Application No: AB/101/21/HH
Site Address: 43 Torton Hill Road Arundel BN18 9HF
Description of works: Erection of two storey side/rear extension, porch to front with associated alterations to fenestration and drainage works.

Thank you for your internet representation made on 28th September 2021 which has been recorded as an objection with the comments as follows:

AB/101/21/HH - 43 Torton Hill Road Arundel

NOTES

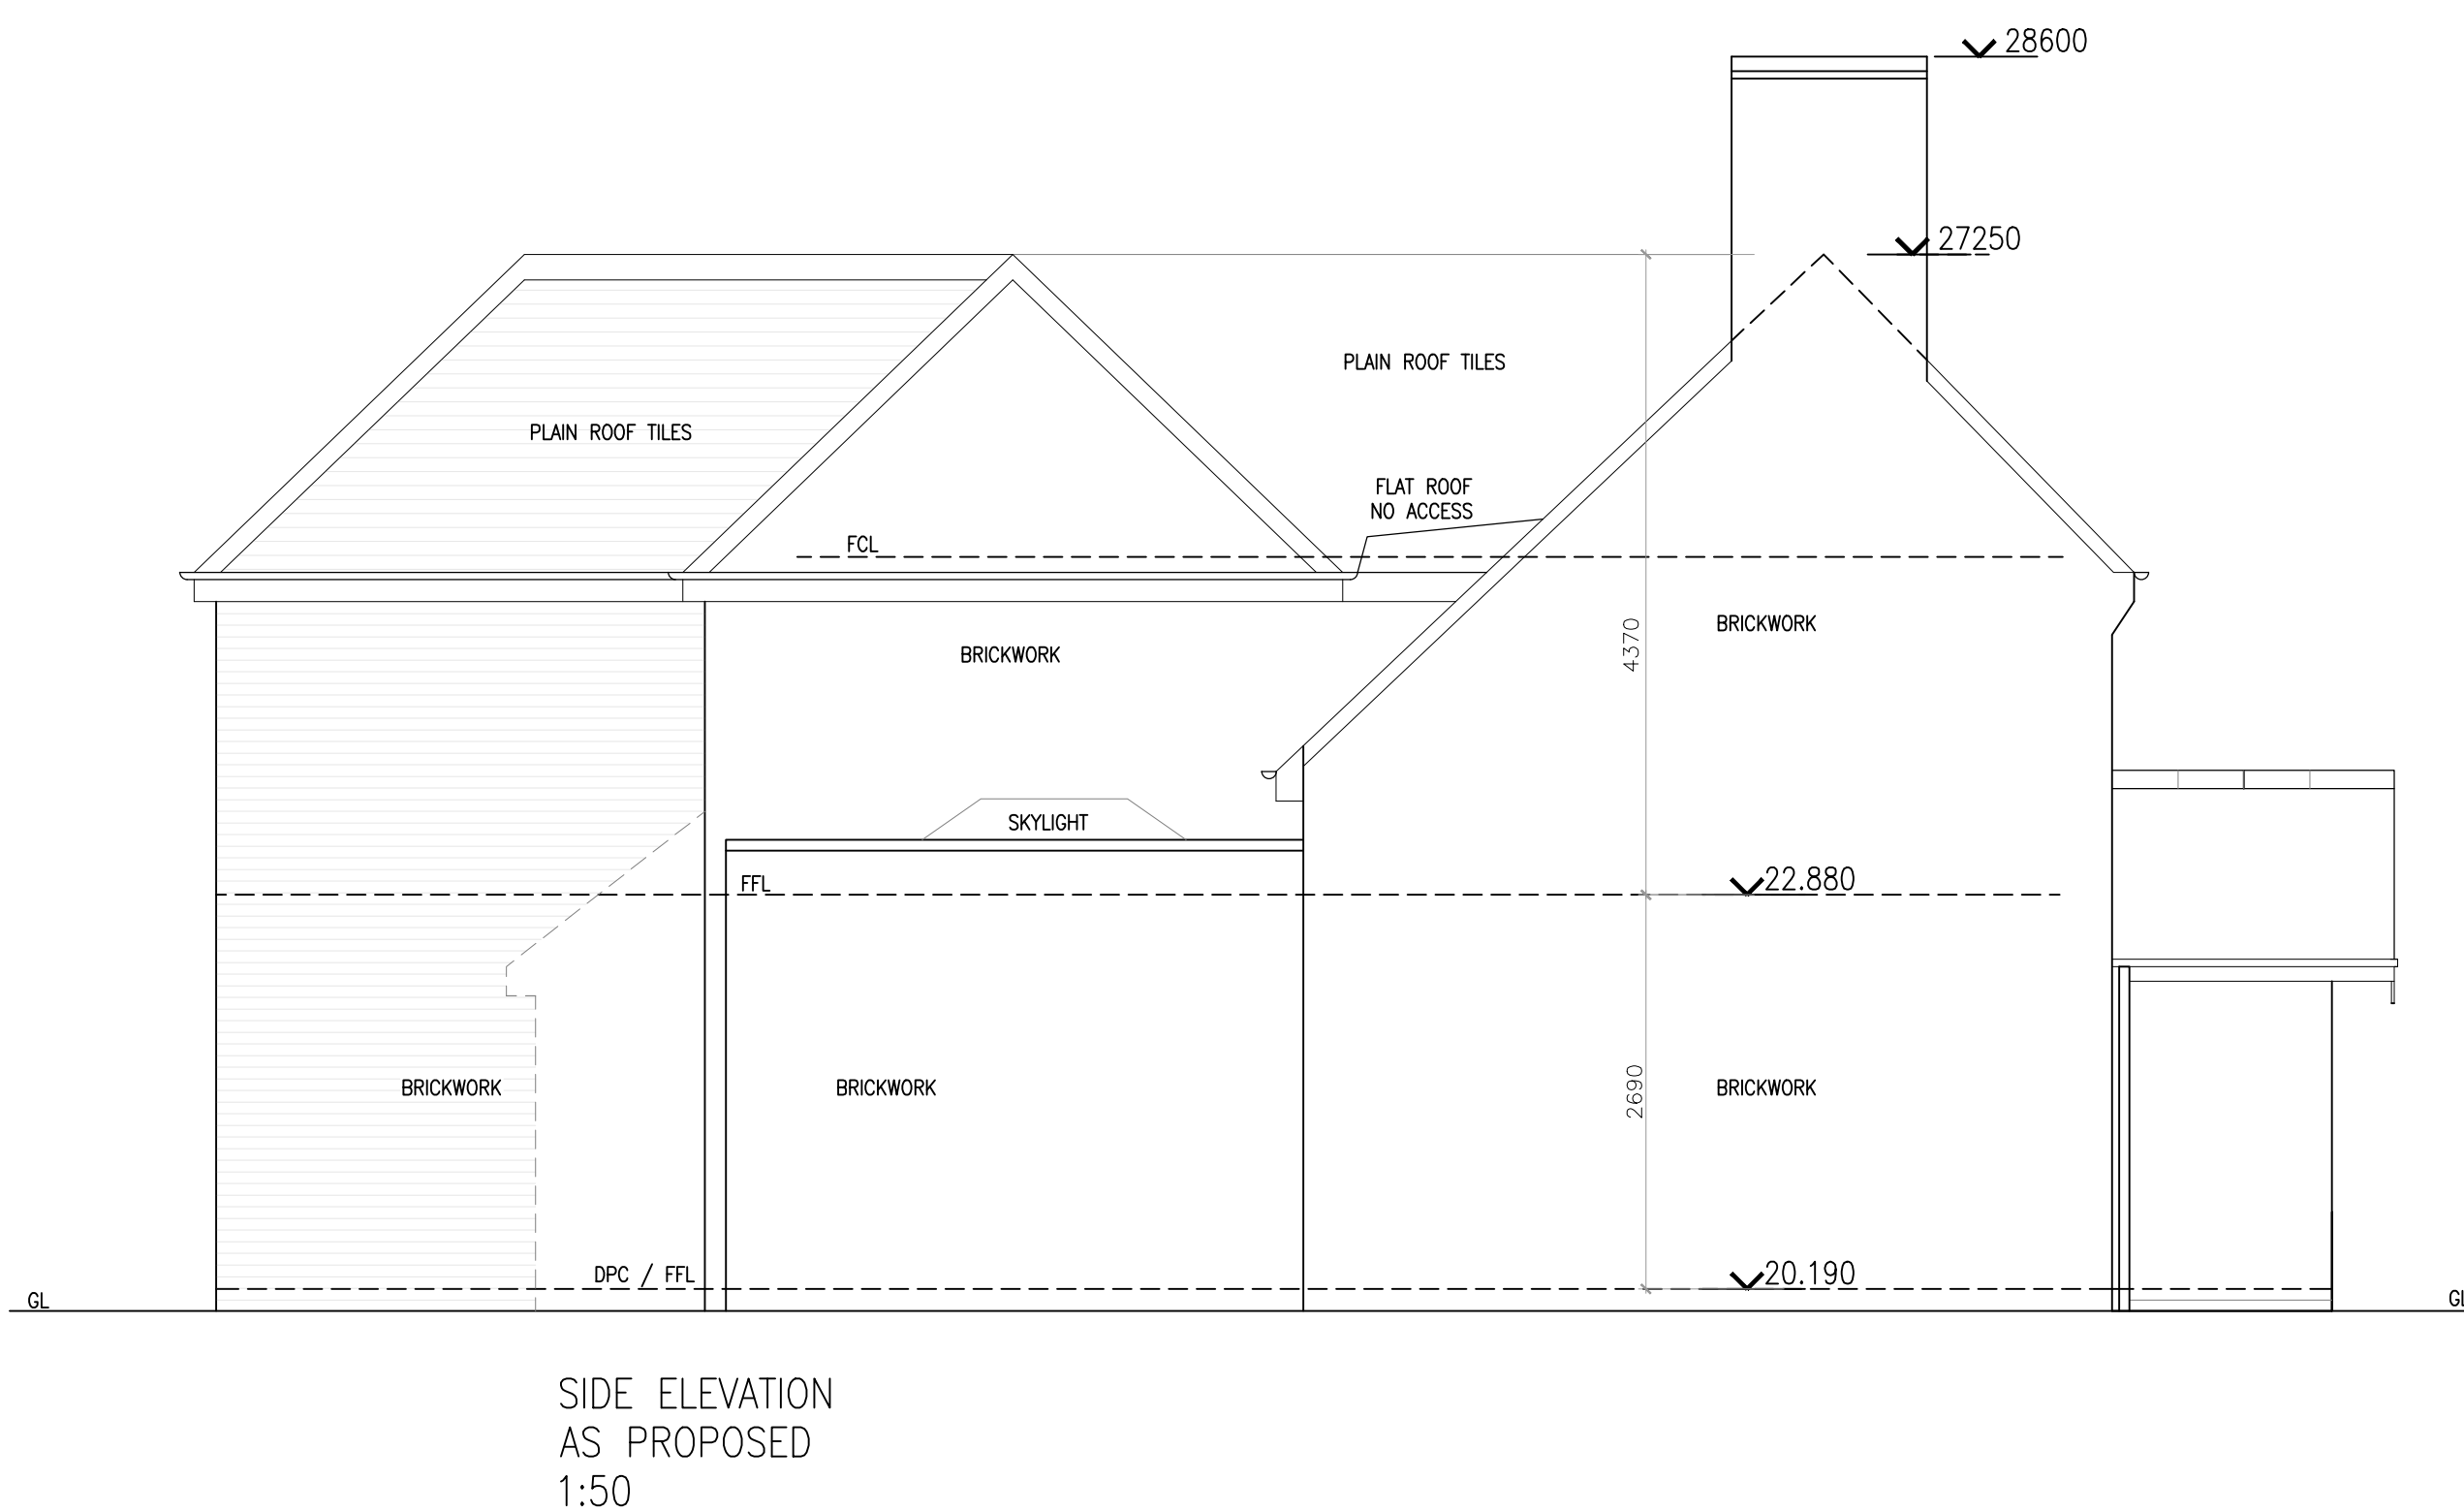
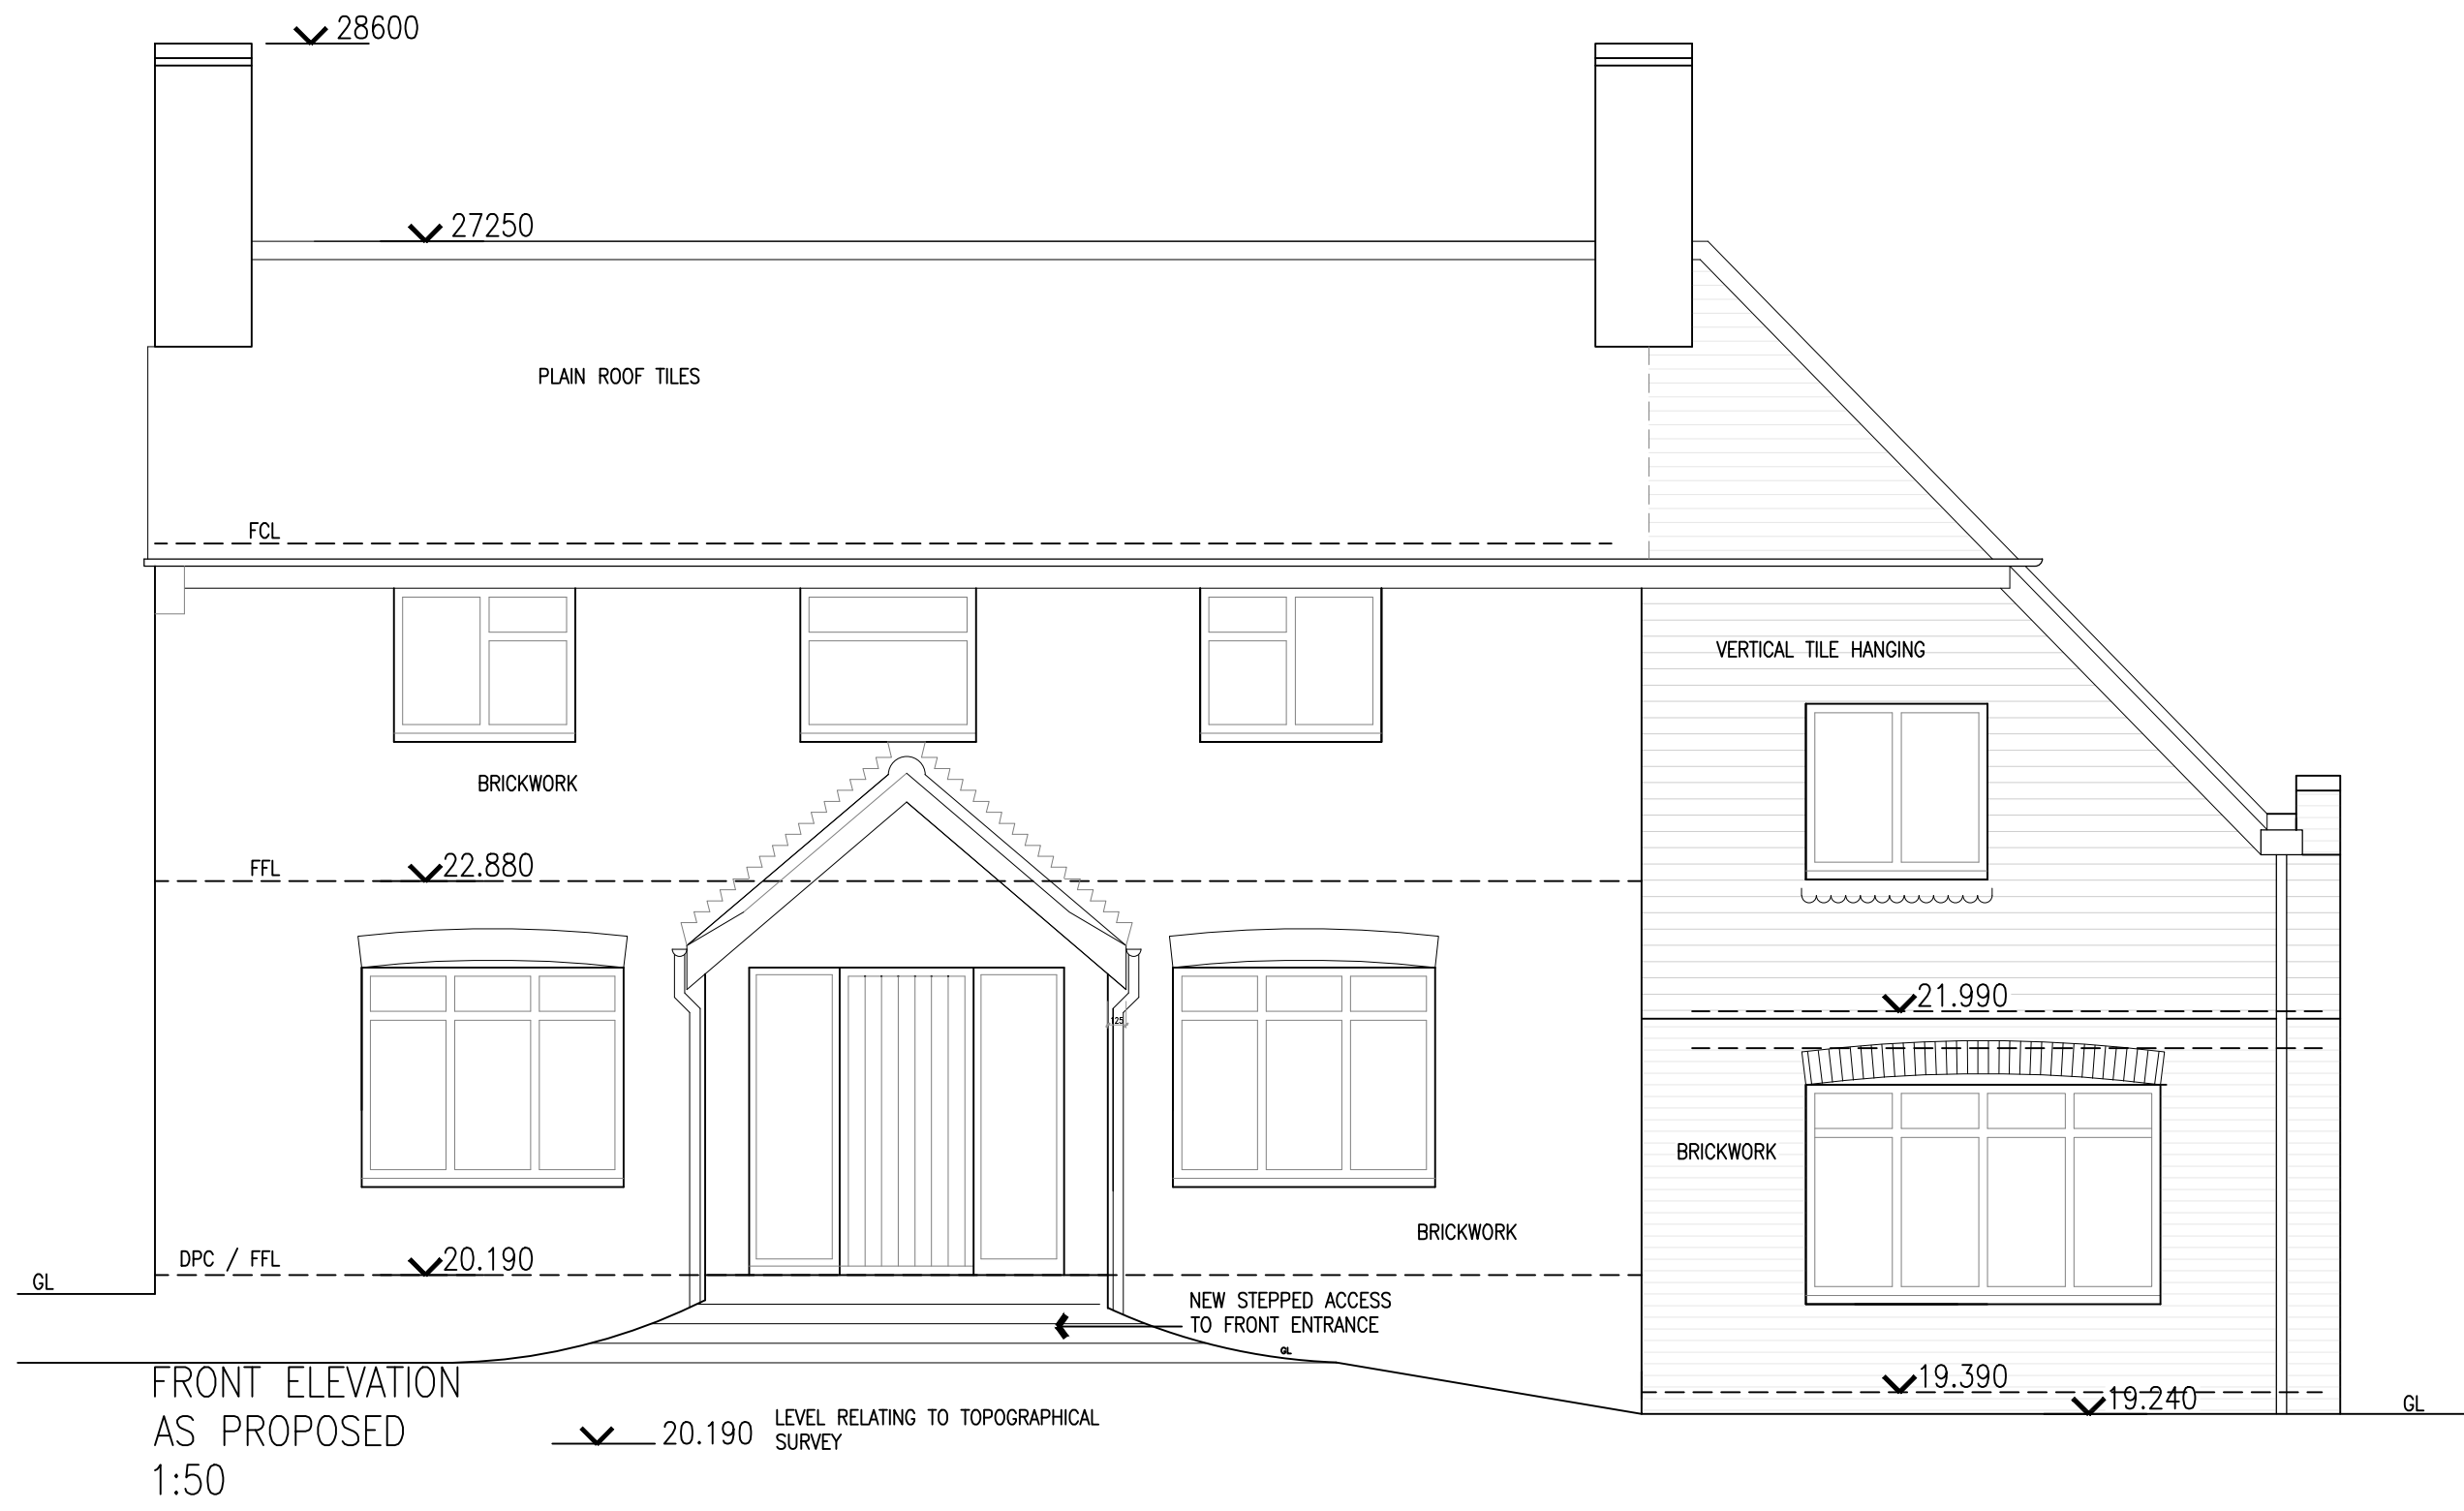
- Side Extension - Objection to the addition of Velux windows along the side extension as this will impact on the privacy of 45 Torton Hill Road. There are two Velux windows at 45 Torton Hill facing directly opposite the party wall for the proposed extension. Due to the proximity between the two houses this will compromise the privacy because four Velux windows on the proposed side elevation are of a size, height and angle that will allow direct visibility into the existing Velux windows (lavatory and family bathroom) of 45 Torton Hill, compromising privacy. In addition, windows will allow direct observation into both side and rear patio gardens removing the only private space in the garden for number 45.

- Side Extension - The intended works clearly encroach on the existing party wall shared by 43 Torton Hill and 45 Torton Hill. For the record, of concern to the owner of number 45 it seems that the party wall will be heightened and modified, terminating in a parapet at the gable. Therefore, as the owner of number 45 I would require provision to drain rainwater runoff without any encroachment on / or over the parapet for number 45. Runoff to be contained/ drained to existing points under Part G (2015) Building Regs.
